Rezoning Transportation Analysis

Petition Number: 2021-127

Revision Log:

Date	Description
09-23-2021	First Review (KP)
11-22-2021	Second Review (KP)
12-28-2021	Third Review (KP)

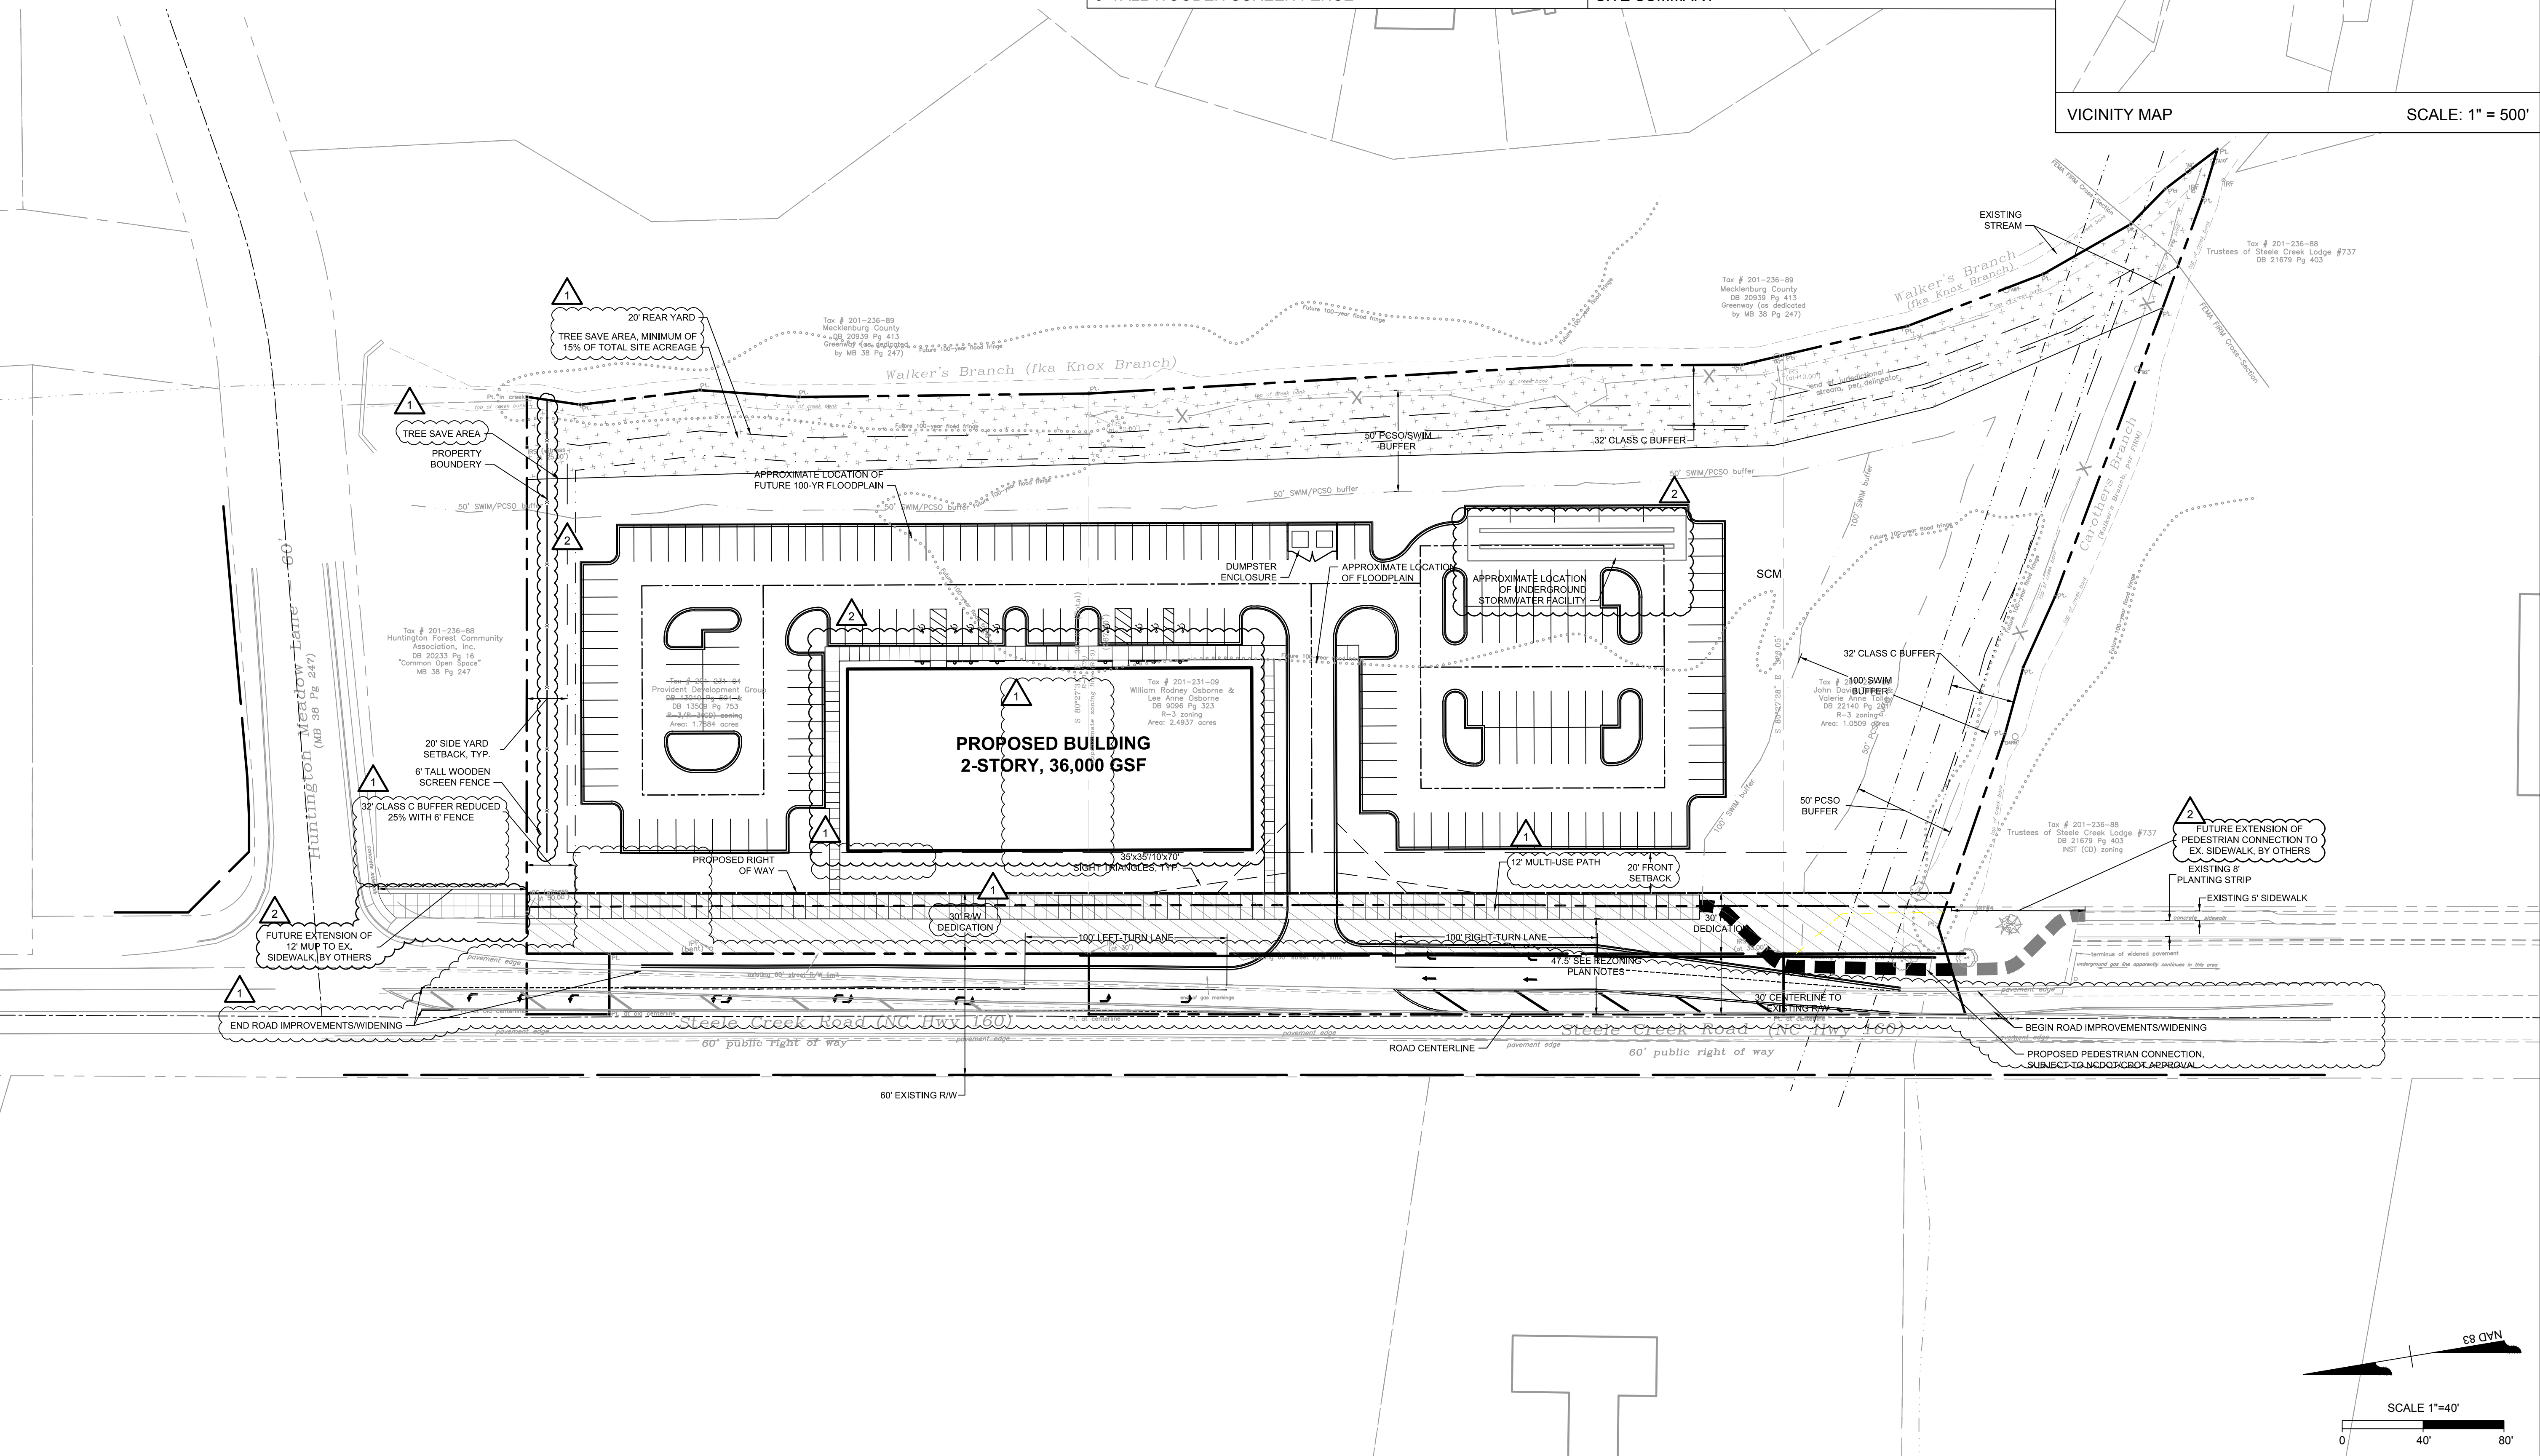
13. ~~New Comment as a Result of the 11-15-2021 Site Plan:~~ Revise the site plan by clearly labeling the existing and proposed striping, on Steele Creek Road, by the approved Parkside Crossing Development (SDRMU 2021-00003).

Label and dimension the future back-of-curb from the existing road centerline.
